From: DataSpace Consult [system@dataspaceconsult.co.uk]
Sent: 12 November 2014 14:37
To: Planning
Subject: Comments Added: Lands Southeast of Northaw Road East (Cattlegate Farm), Cuffley

Application ID: S6/2014/2292/FP - Mr M Peacock Application Owner: Welwyn & Hatfield Borough Council (Development Management Officer)
Applicant: Metropolis Planning & Design
Location: Lands Southeast of Northaw Road East (Cattlegate Farm), Cuffley Deadline Date: 14/11/2014 00:00:00
Description: Installation of pipework to provide a primary distribution heat network
Comment Added:

Location Plan

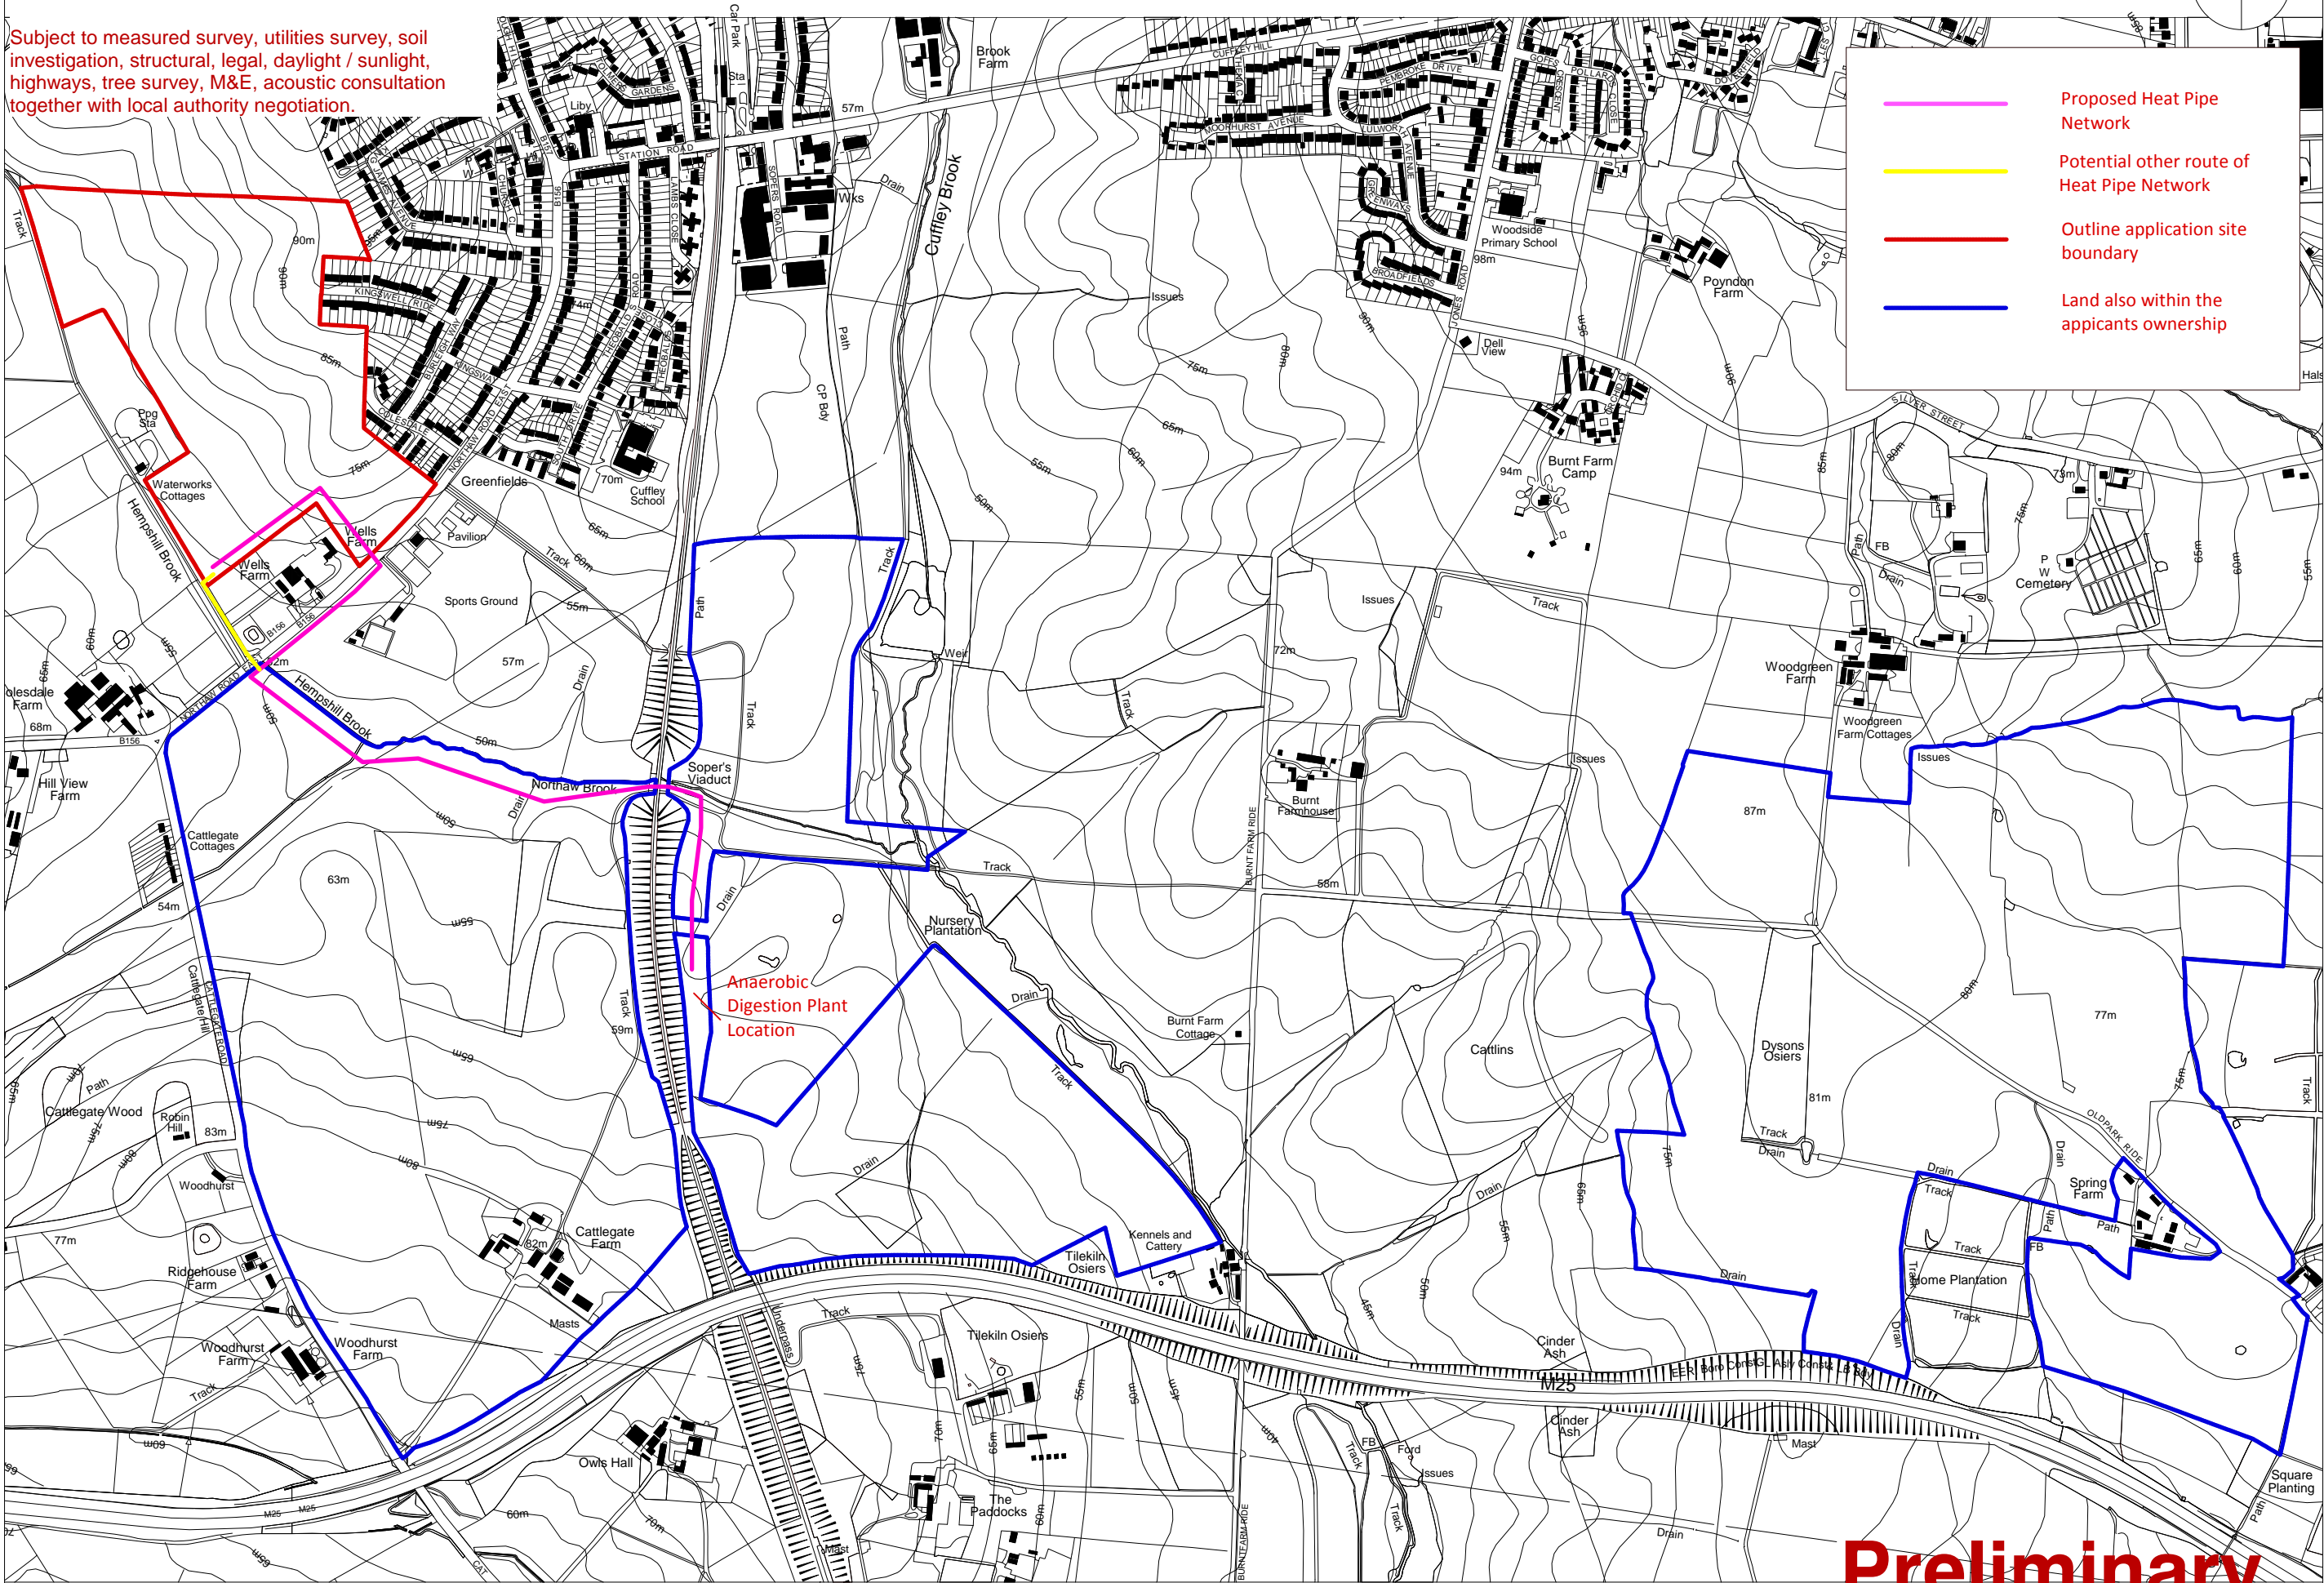
We understand that in some similar District Heating Schemes, for instance a recent scheme in Southwark, there were a number of above ground structures such as Inspection pits, Manholes and Small Plant Housings. These types of structures seem to be needed at key points, particularly at 90° levels.

We understand that there are no above ground structures shown in this application and we find this to be a questionable assumption.
